22nd March 2013

Senior Environmental Planner
Major Development Assessment
Department of Planning and Infrastructure
GPO Box 39
SYDNEY NSW 2001

**Orica Southlands Remediation & Warehouse Development Project
Modification Application (MP 06_0191 Mod 1)**

Southlands Industrial Estate **Figure D9a**
Final Development Scenario 50% AEP flood level difference map

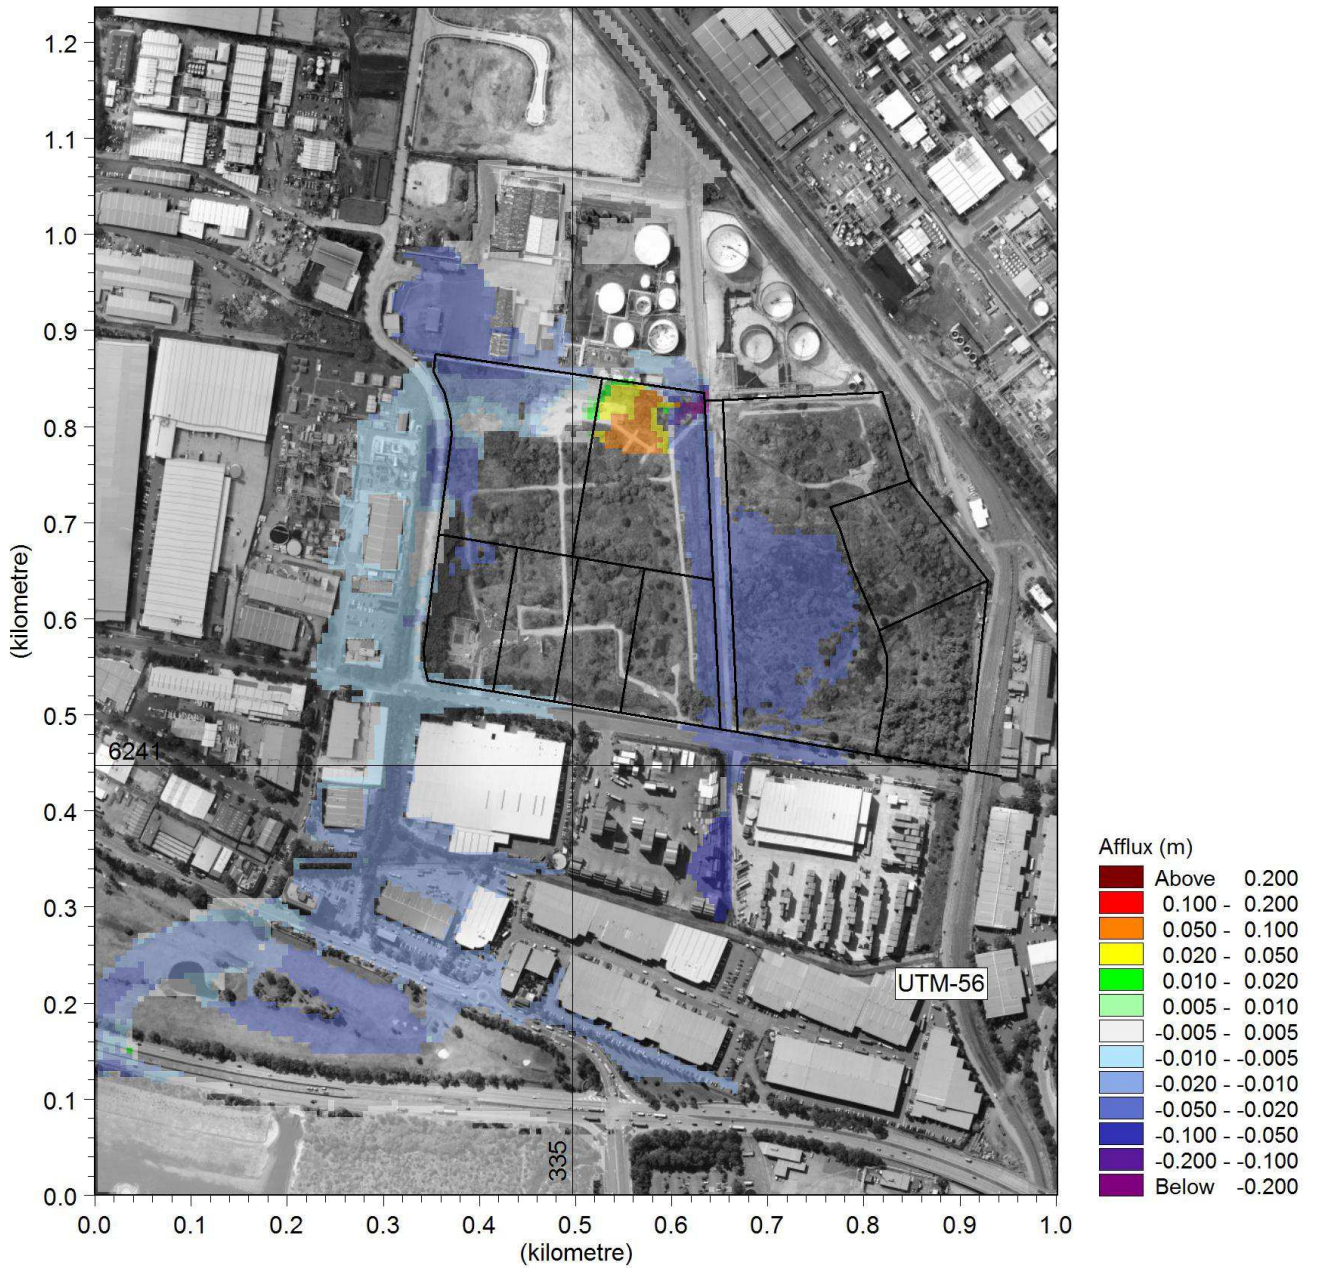
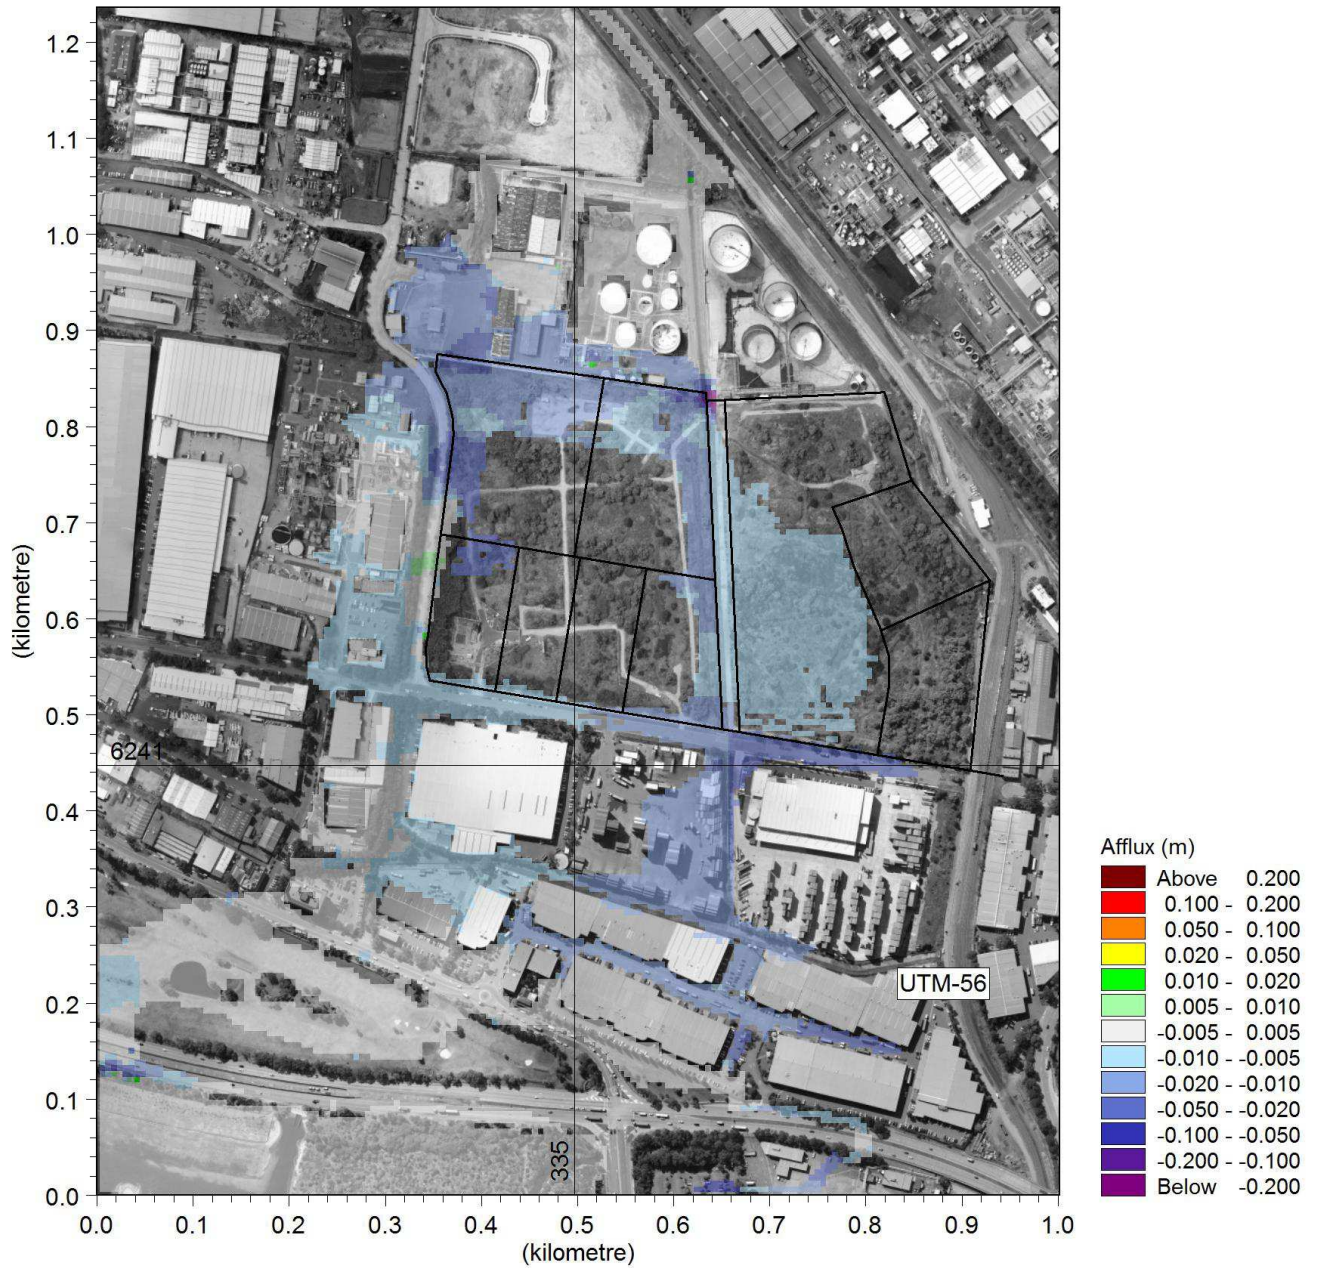
The summary report by Aurecon for the revised works concludes under the section on model results, that "there is no afflux on adjoining properties and in fact leads to a decrease in flood levels". This would not appear to be correct, particularly in the case of the 2 and 10 year event modelling. The original Stage 1 flood level difference maps ie Figures D9 and D10 show flood difference levels over our site "Below -0.02 ", whilst the revised maps D9a and D10a show food difference levels of "-.005 – 0.005 & -0.010 - -0.005" metres. This indicates that the flooding level in these cases would be higher than modelled in the approved Stage 1 development. The situation in regards to the 100 year event is not as clear from the contoured maps, but again does not appear to represent a decrease in flood level.

Conversely with the contouring of the new detention area on the northern end of the Stage 1 development, Solvay Interlox Pty Ltd would expect to see significant increases in flood level difference maps, not a reduction in levels as indicated in Figures D9a, D10a and D11a.

SRD DA0.17 (H)

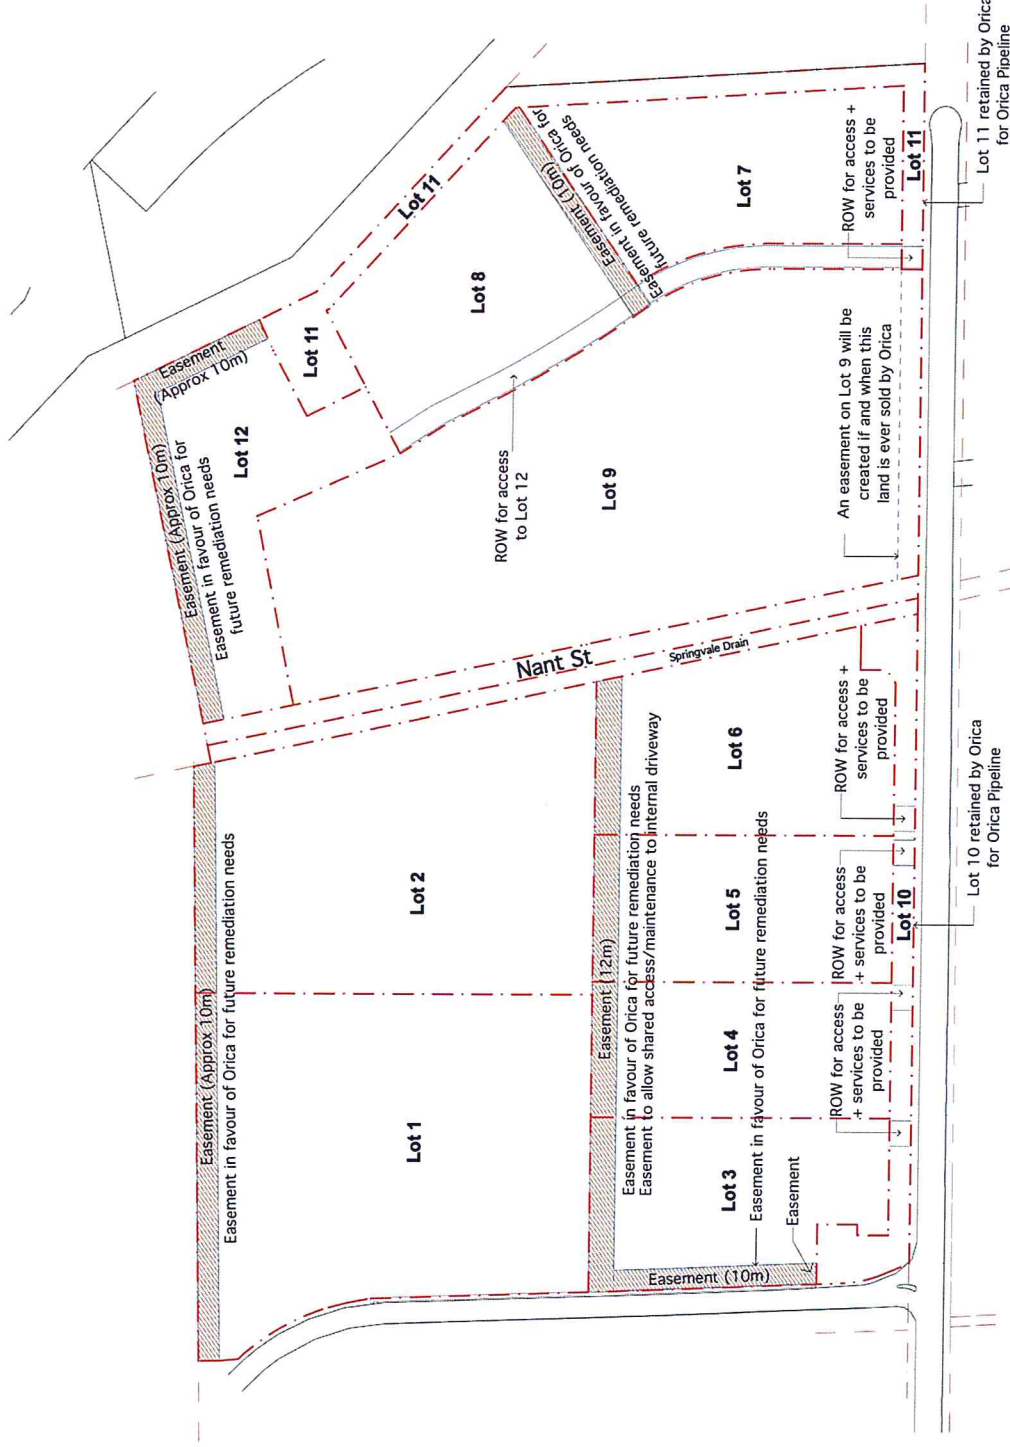
The latest Proposed Easement drawing no. SRD DA017 (F), only shows easement on the northern part of the Southlands site between Floodvale and Springvale Drains. There is no easement shown on the eastern side of Springvale Drain.

The Proposed Easements drawing should be revised to show Solvay Interlox Pty Ltd's easement through the entire northern section of the Southlands site.
